Permit Number: 040657

This is to certify that Jordan John R /Greg McCormick c/o Portland
has permission to build 26' x 42' single story dwelling + 22' x 22' attached garage + 10' x 10' deck
AT 450 Ray St 400 D008001

From: Jay Reynolds
To: Greg McCormick
Date: Thu, Jun 17, 2004 1:21 PM
Subject: Review Comments- 450 Ray Street

Chart 400, Block D, 678
 (ADDRESS UNASSIGNED)

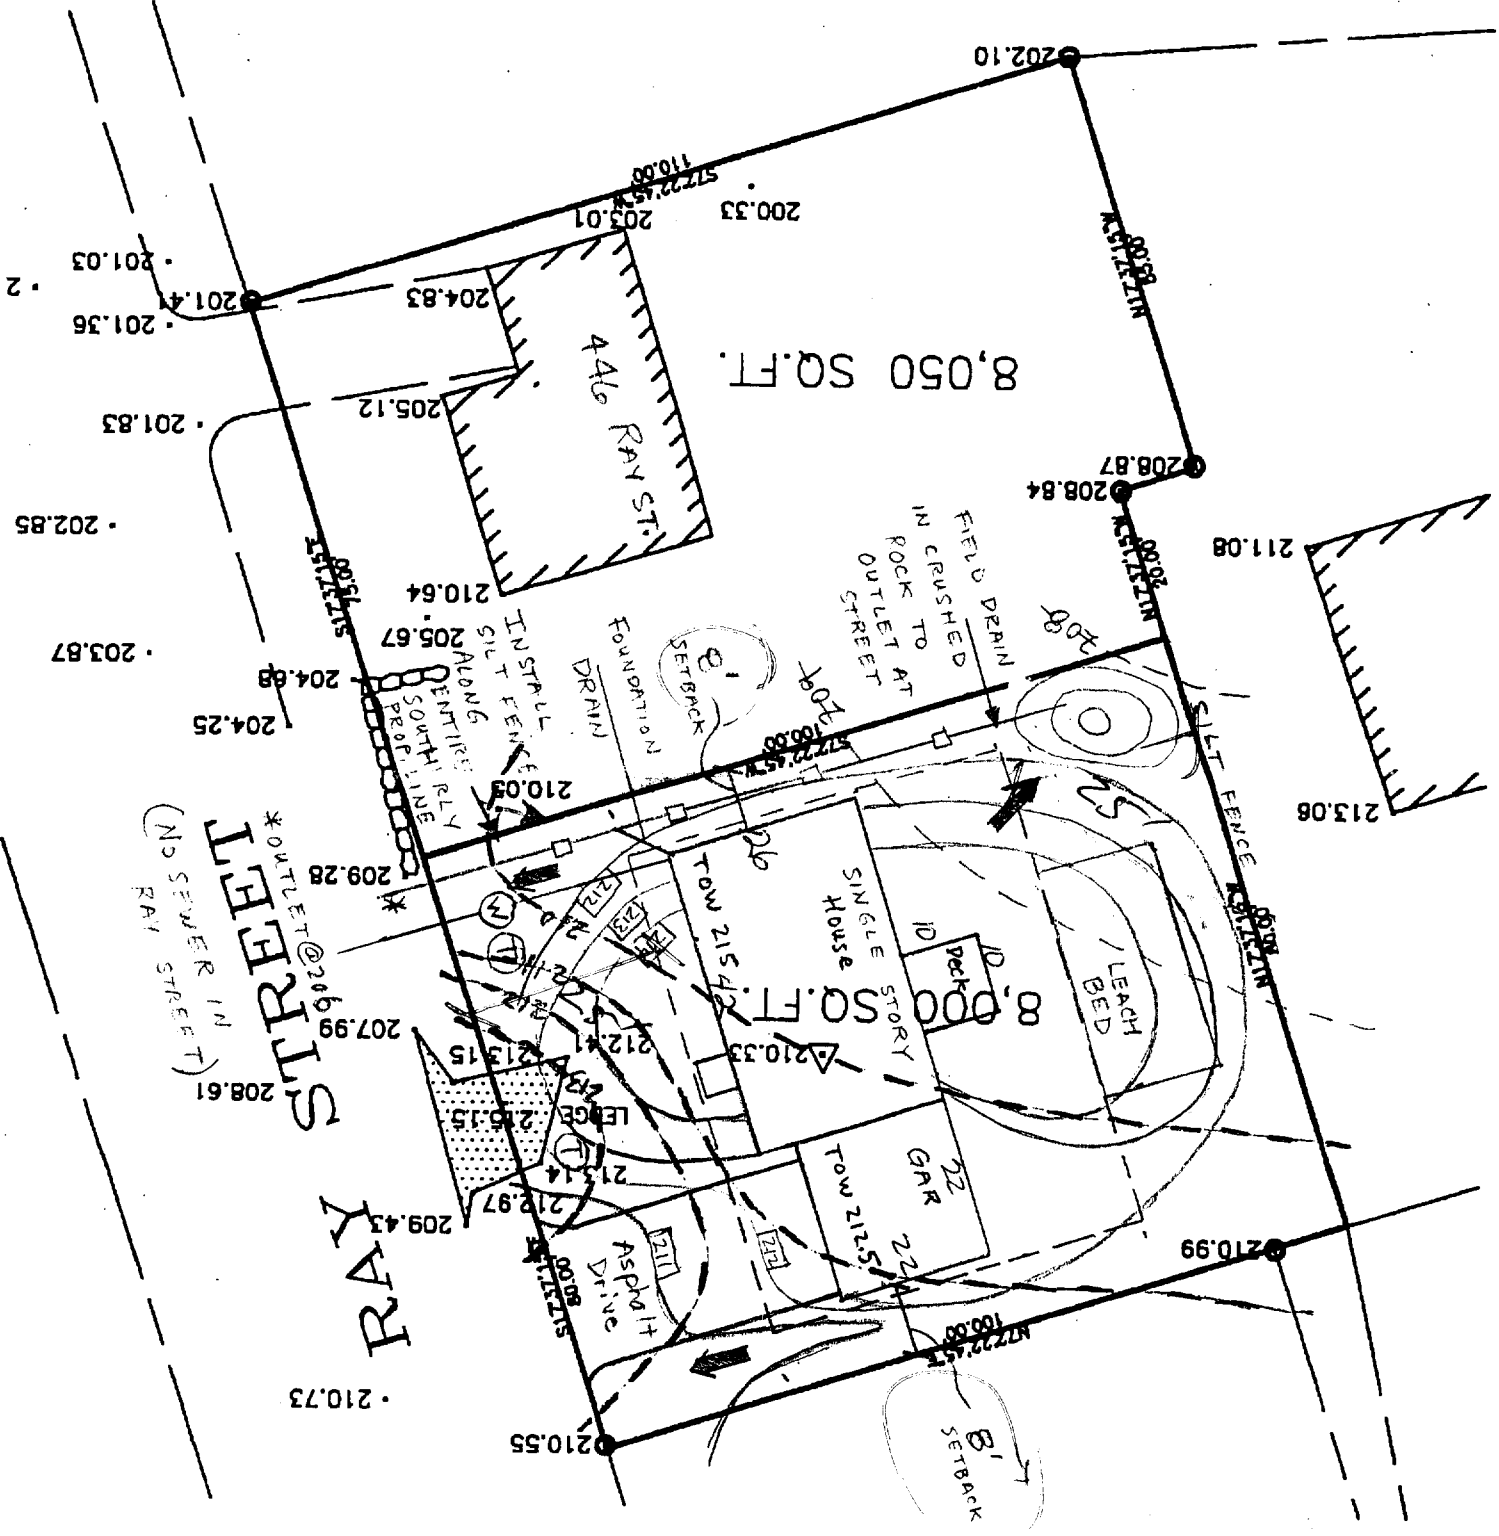
1. It appears that Ray Street in this vicinity has been paved within the last 5 years (Aug. 2001), and that moratorium fees will apply to your street openings.
2. After speaking with City Engineer, Eric Labelle, he has indicated that this lot, being within 200 feet of a public sewer, would be required to connect to the City infrastructure. This, as I understand, has already been discussed with you.
3. The field inlet is a great idea, however, more information is needed regarding the outlet at the edge of roadway. Will this daylight at the pavement edge or does it tie into an existing line? This outlet, out in the Right of way, will have to be satisfactory to the Public Works Department.

TYPICAL FOUNDATION WALL SECTION - MAIN HOUSE

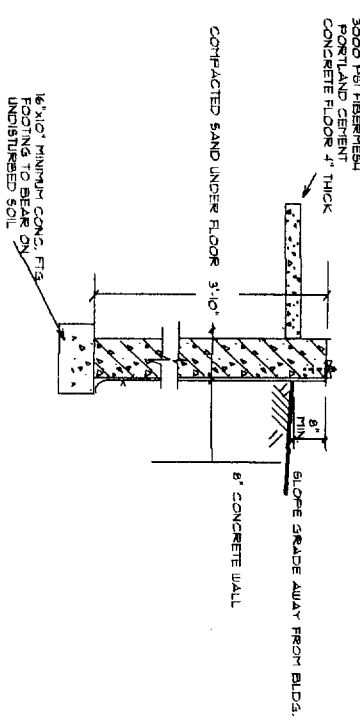
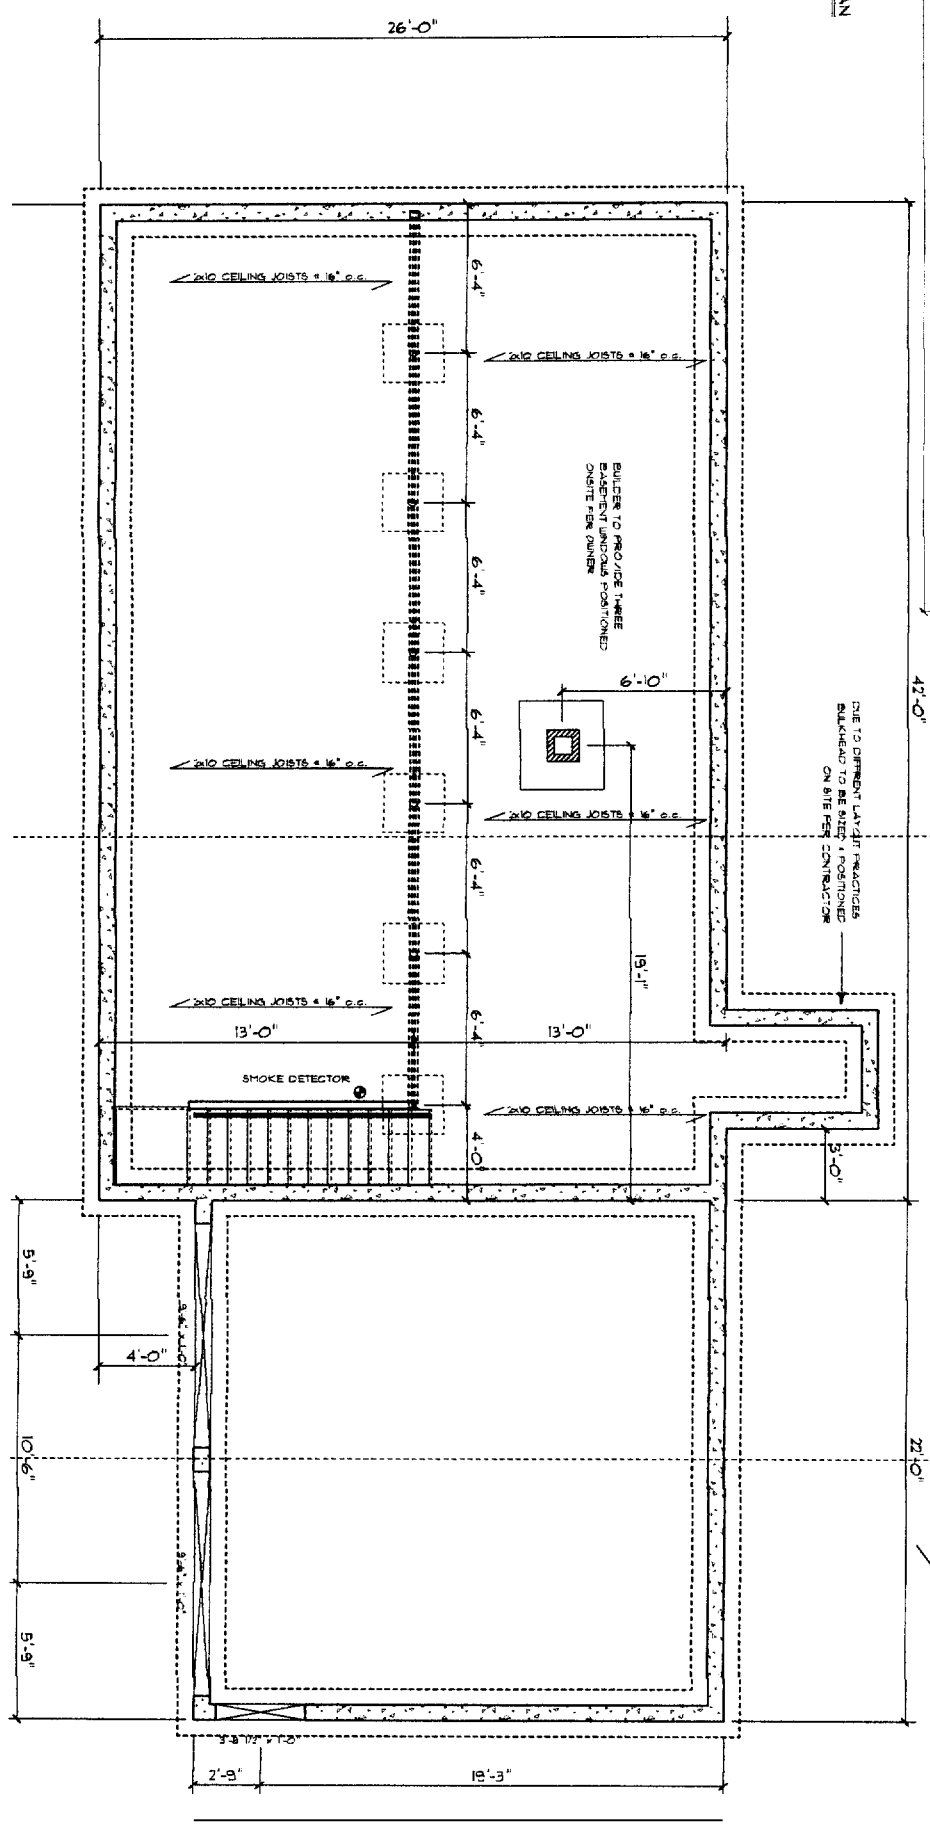
Gauge Headers - ~~Feu~~ reg 3-2x12 or LVL if ^{16'} OK
